From: [REDACTED]
Sent: 08 December 2025 12:22
To: Planning <Planning@arun.gov.uk>
Subject: PLEASE ADD TO MY PLANNING OBJECTION SEEE 45 DEGREE RULE TO ADD

Dear Sir/Madam,
Town & Country Planning Act 1990 (as amended)
Town & Country Planning (Development Management Procedure) (England) Order 2015
Application No: R/215/25/HH
Site Address: 21 Sutton Avenue Rustington BN16 2ES
Description of works: Single storey rear extension.

Drawing:  
**Plans and elevations as proposed**

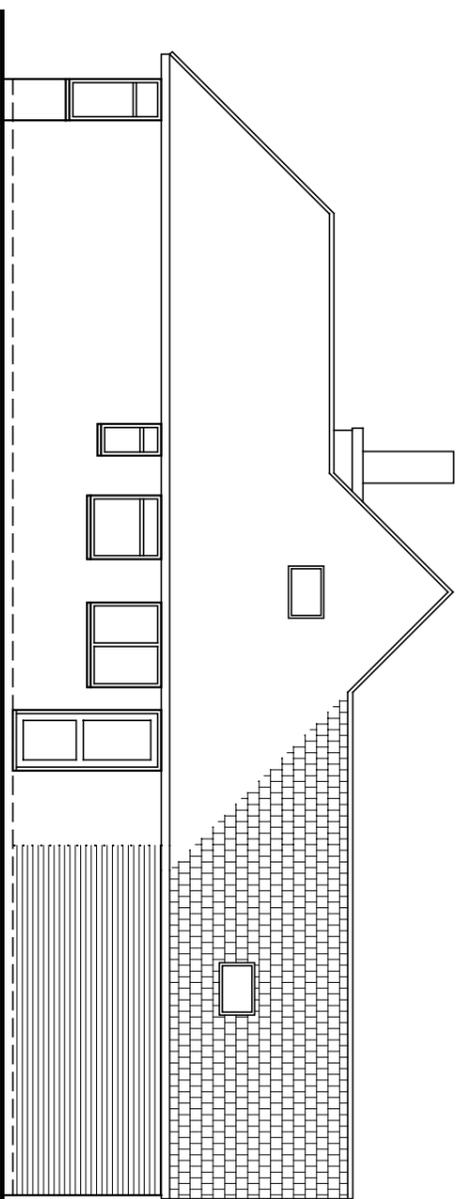
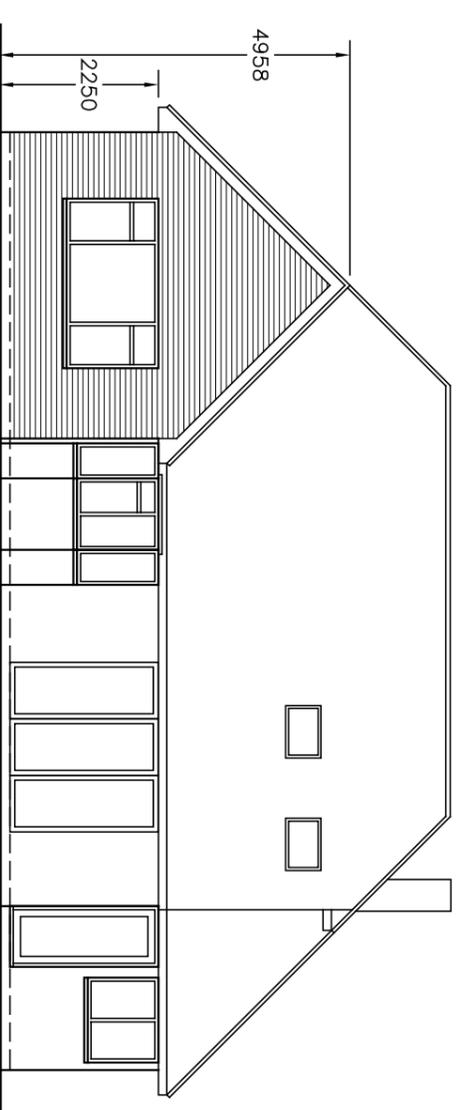
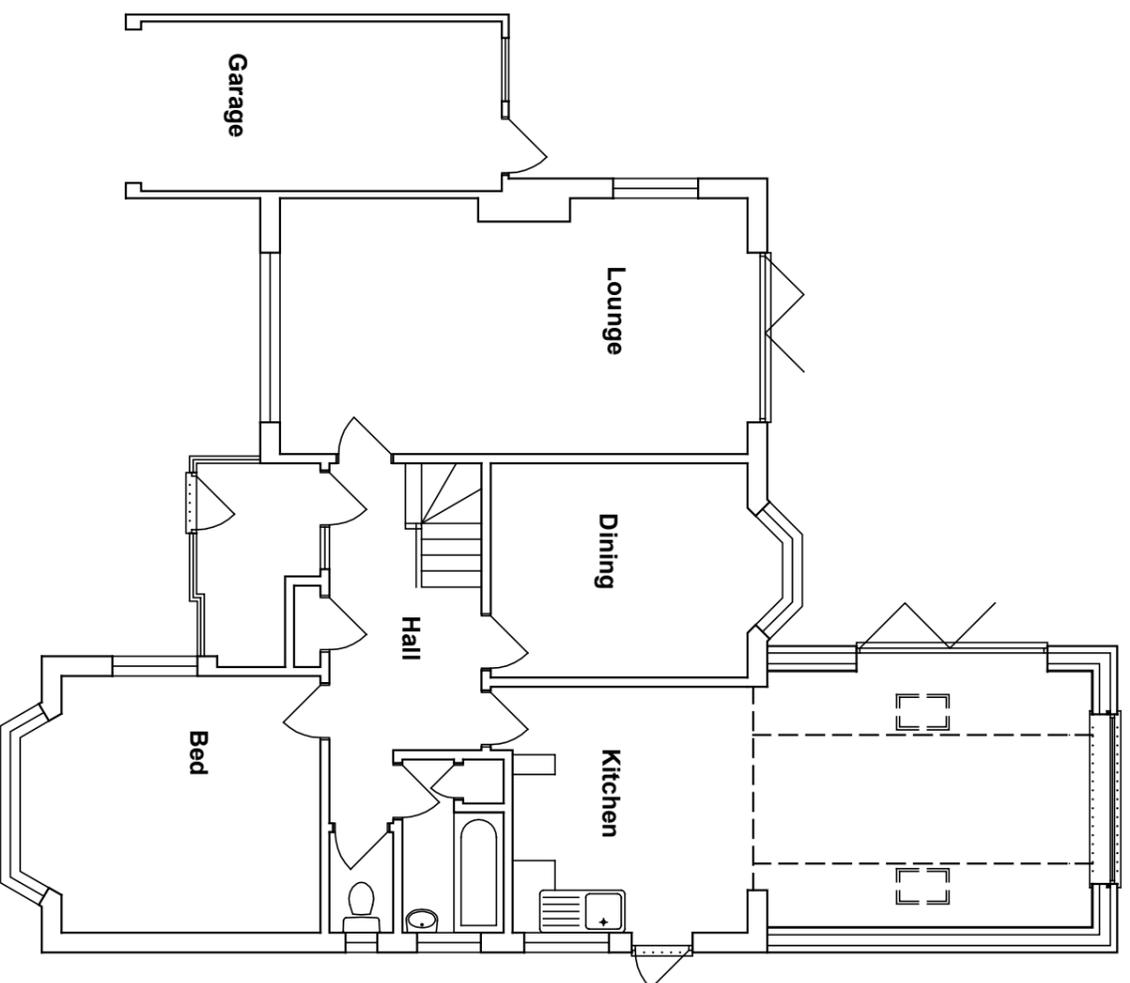
THOMPSONS EXTENSION ON " MY SOUTH SIDE BORDER FULLS WITHIN A "45 DEGREE RULE" ANGLE TAKING MY CLOSEST WINDOW,
,LIVING ROOM ,CENTRE OF WINDOW
TO THEIR PLANNED EXTENSION"

HAS BEEN MEASURED FROM CENTER OF MAIN LIVING ROOM WINDOW WHICH IS CLOSEST TO THEIR P[LANS EXT.

Thompson family are trying to build within "45 degree angle" you will see on their plans, which will block light, heat push us both into dark, see centre of main living room window and

their plans for extension fall in angle
